Civil Engineer
Stormwater Best Management Practice (Permanent) Certification Letter

CLAREMONT BUSINESS PARK 2 FILING NO. 1
 WATER QUALITY POND 2 CERTIFICATION
 PROJECT NO. 44-037
 SCALE: HORIZONTAL: N/A VERTICAL: N/A
 DATE: 12/3/21
 SHEET 1 OF 1
 BMP01

SAND FILTER WATER QUALITY POND 2 (PRIVATE)

SAND FILTER WATER QUALITY POND 2 (PRIVATE)

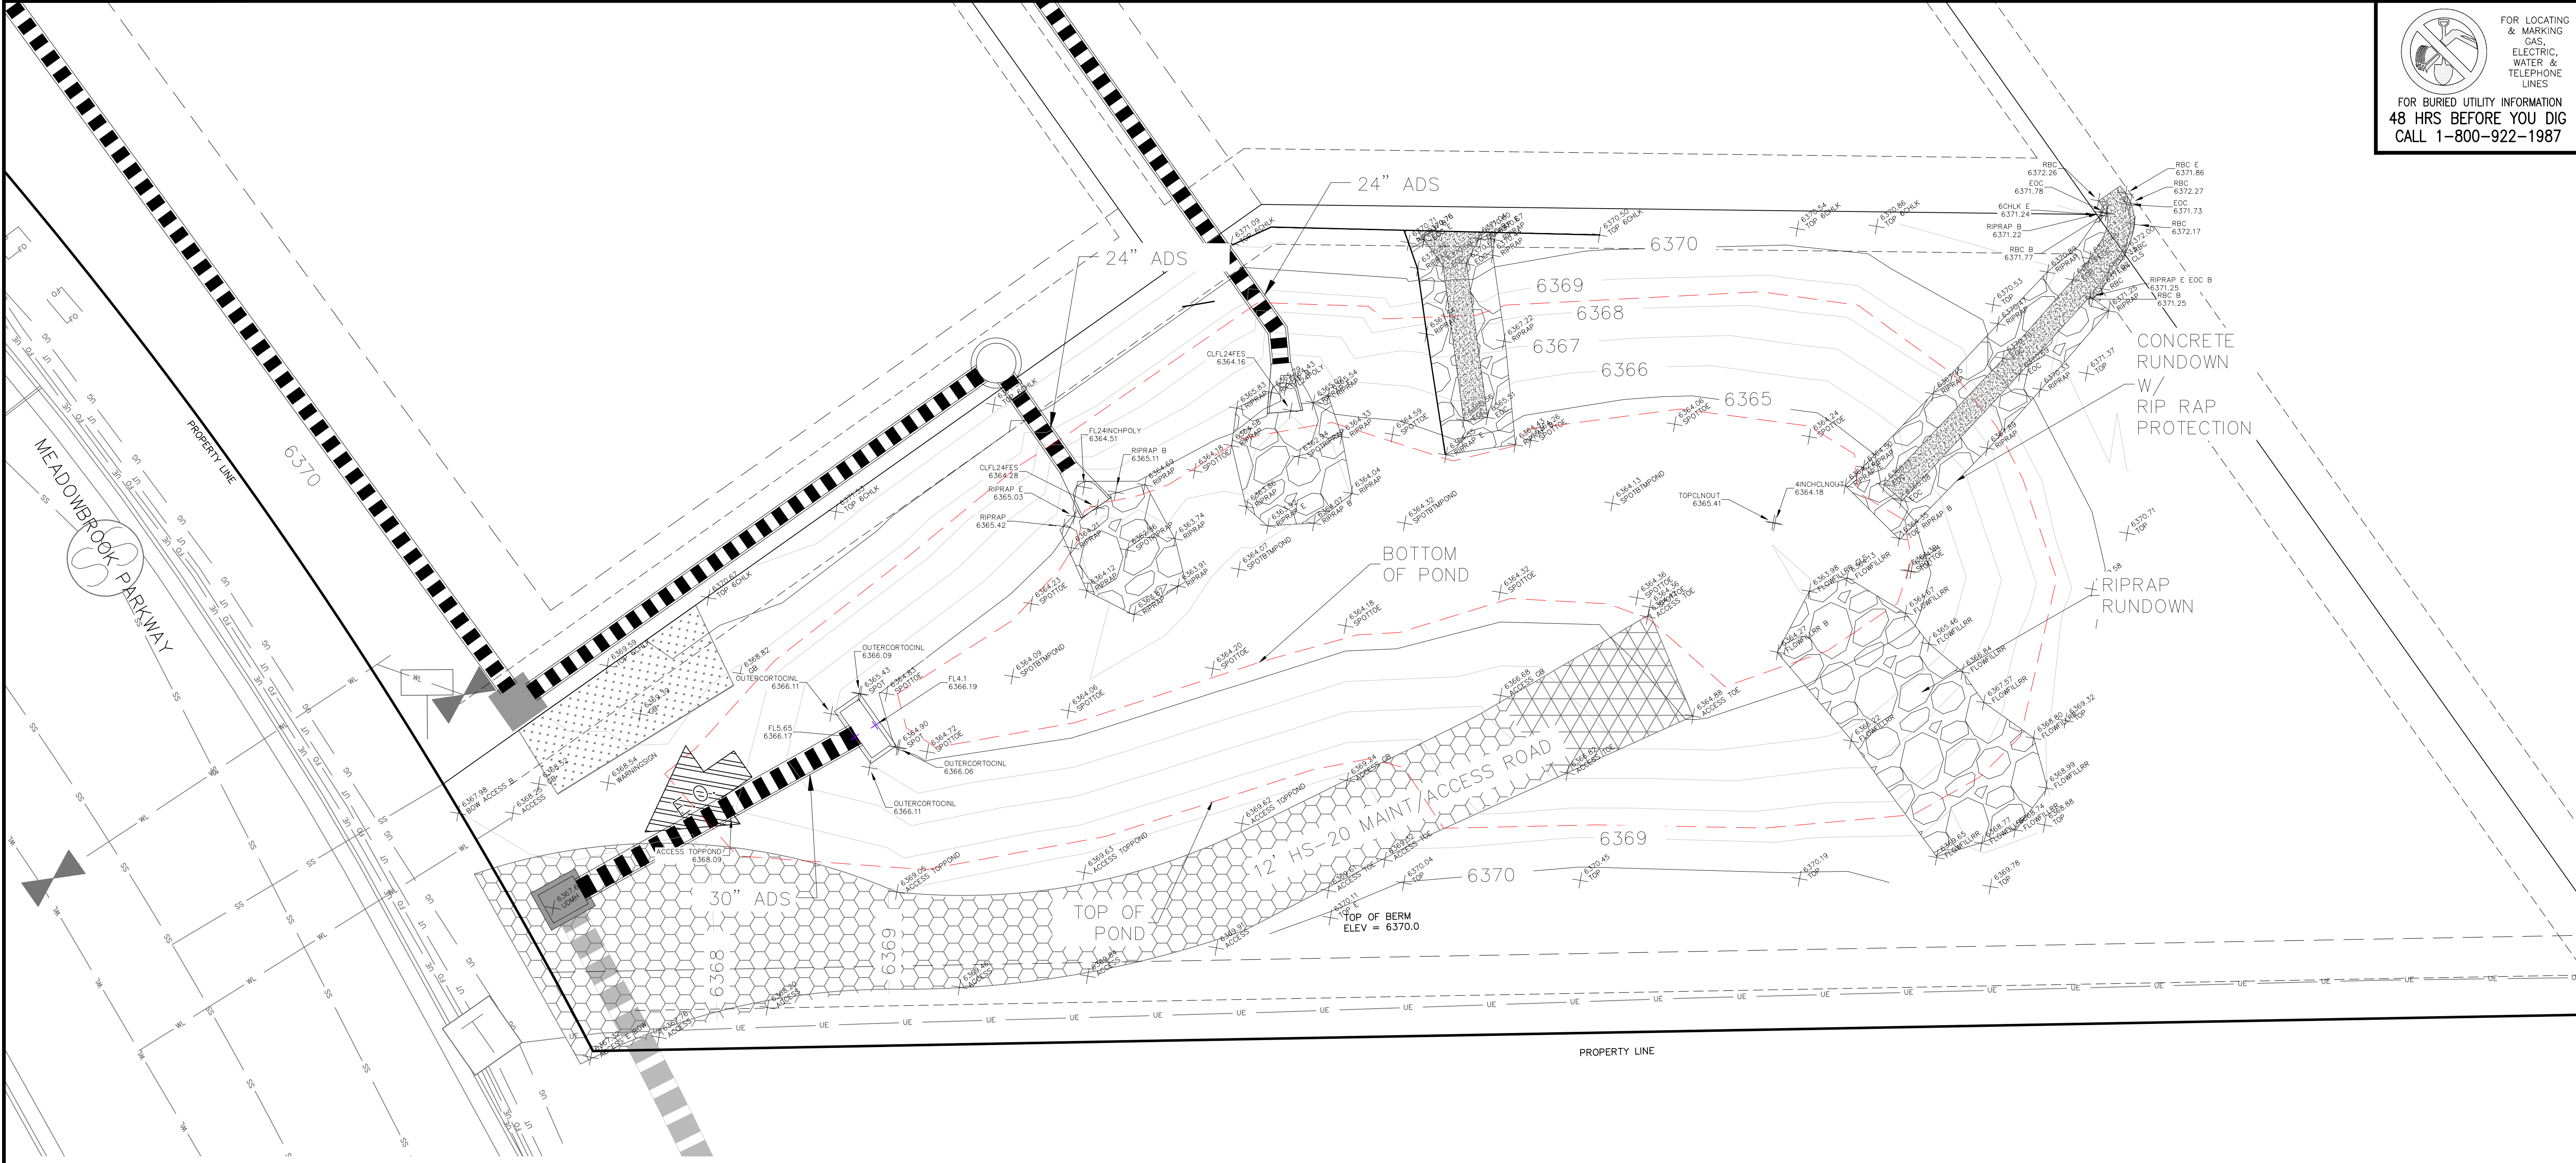
page 9 of 13 of latest as-builts shows a difference of 0.09ft between designed and as-built. But these calc sheets show a difference of 0.14ft. Please revise to remove discrepancy.

page 9 of 13 of latest as-builts shows a difference of 0.06ft between designed and as-built. But these calc sheets show a difference of 0.23ft. Please revise to remove discrepancy.
